**KIRKLEES METROPOLITAN COUNCIL
INVESTMENT & REGENERATION SERVICE**

DELEGATED DECISION TO DETERMINE PLANNING APPLICATIONS

Reference No:	2023/60/91963/W
Site Address:	Land Adj, 6, Reinwood Avenue, Quarmby, Huddersfield, HD3 4DP
Description:	Outline application for erection of detached dwelling
Recommending Officer:	Tom Hunt

DECISION – REFUSED

PROPOSED STREET SCENE NORTH ELEVATION

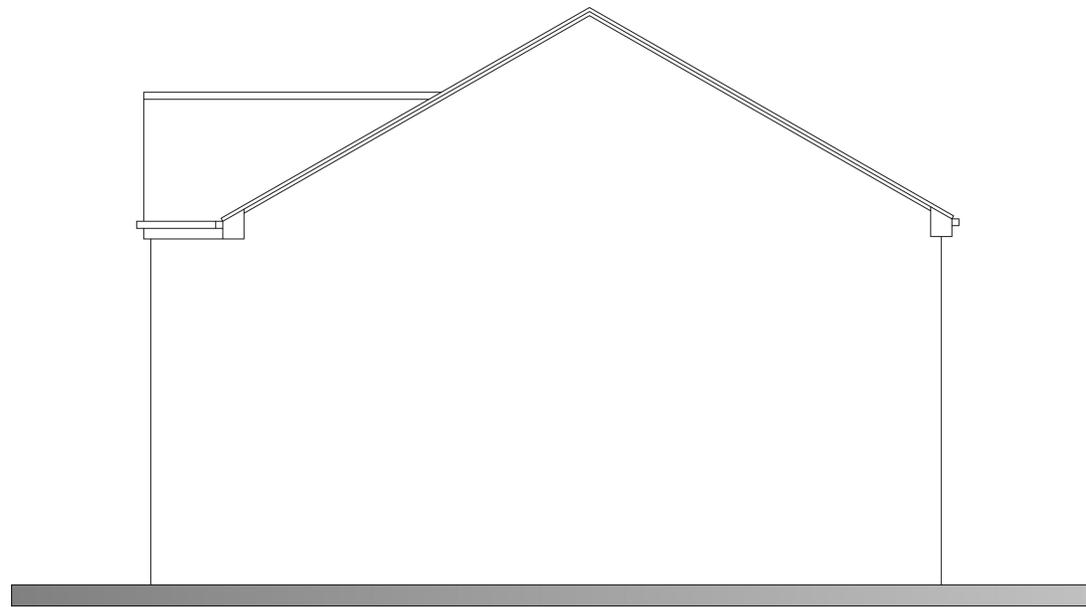
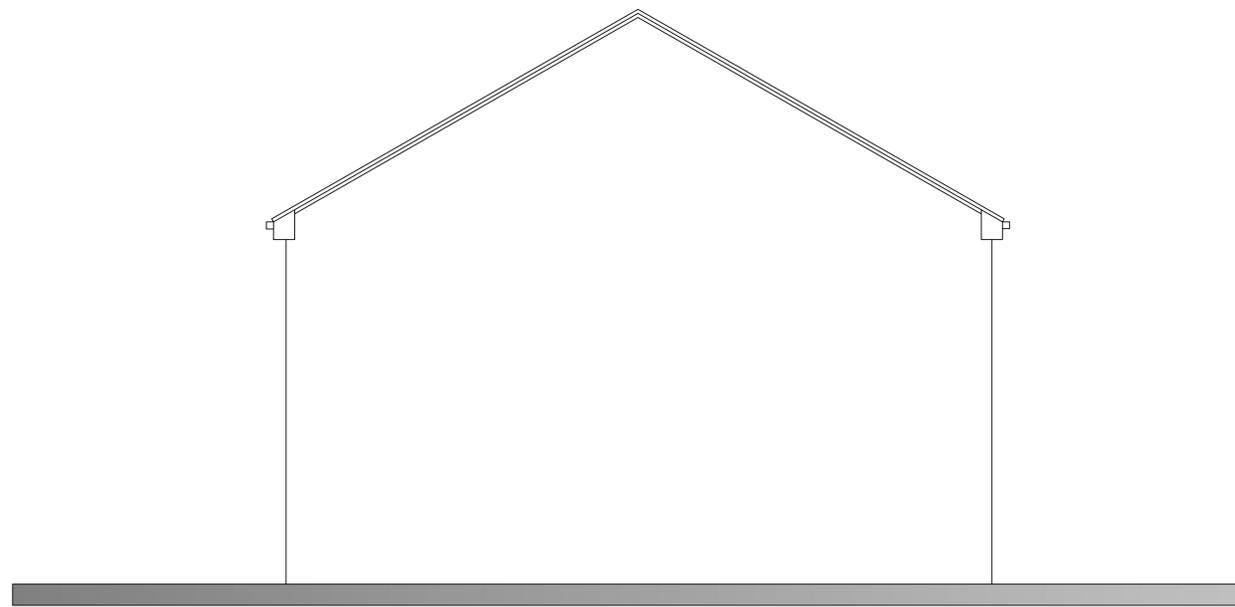
It is acknowledged that all matters are reserved including appearance, scale, layout and landscaping. Indicative detail was provided in terms of an incomplete streetscene elevation plan which poorly showed the application site's relationship between no. 4 and no. 6, it demonstrated that a proposed detached, two-storey dwellinghouse would be lower in height than no. 6 and set within lower ground would also appear visually less dominant in height than this neighbour. It would have a dwellinghouse of moderately greater width to this neighbour in isolation, however this would be situated in a streetscene of semi-detached properties appearing as an isolated form of piecemeal development poorly connected to its setting. This would be further enhanced by the appearance of a conventionally proportioned modern property which does not reference the arts and crafts architectural style of the flank neighbours. As referenced previously, there is a strong sense of waves of architectural styles being grouped visually and the current proposal fails to retain this strong sense of character and identity. This impression is further enhanced by the fenestration and roofing style being out of keeping with its neighbours' contrary to Principles 2,14 and 15 of the SPD. Notwithstanding the above, the fundamental concerns of Officers in the harms of creating incongruous additions to the streetscene to create properties within cramped plots, poor

The proposal would have the proposed's two storey bulk and massing, on higher ground level and close set near no. 4 with a minimum of 1.6m to the shared boundary. This scale and massing is concluded to have an oppressive impact leading to an unacceptable loss of outlook and overbearing effect on this neighbour heightened by no. 4's position within its plot which is a lower ground level.
